Your ref:  
Our ref: 23/01700/F  
Please ask for: Lynn-Marie Elliott  
Direct dial:  
E-mail: borough.planning@west-norfolk.gov.uk

Details: **"Retrospective" Extension to rear of the property at 65 Recreation Drive  
Southery Downham Market Norfolk PE38 0NB**

I have received a planning application as detailed above but cannot process it until I receive some more information:

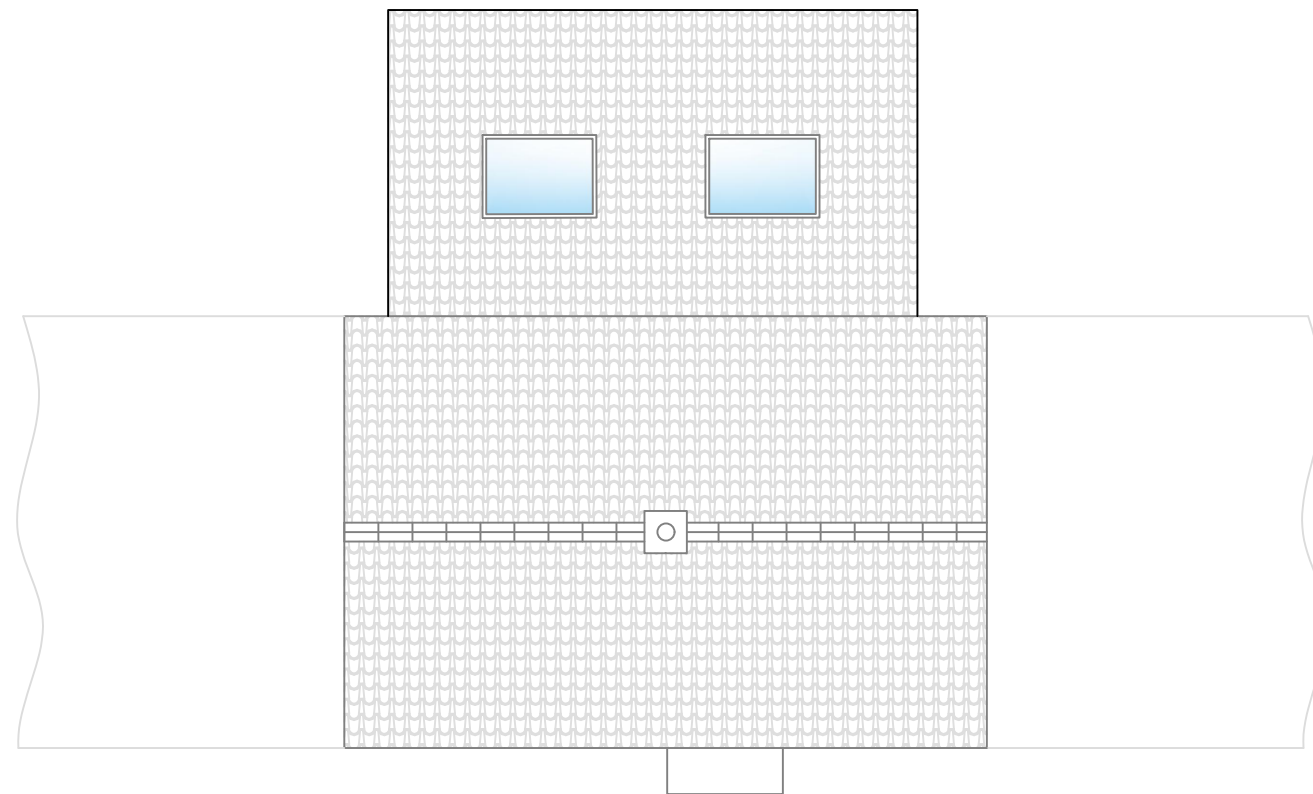
1. As the property lies within an area at risk to flooding, please complete the simplified Matrix and return it. The Matrix can be found at [https://www.west-norfolk.gov.uk/info/20173/information\\_for\\_planning\\_agents/231/flood\\_risk\\_information](https://www.west-norfolk.gov.uk/info/20173/information_for_planning_agents/231/flood_risk_information)
2. Please confirm if site levels are to remain as existing.
3. Please mark on floor plan to specify that they are proposed plans.
4. The annotation on the drawing(s) submitted with your application refers to the drawing being not to scale. Please remove any such reference for the purposes of the planning application.
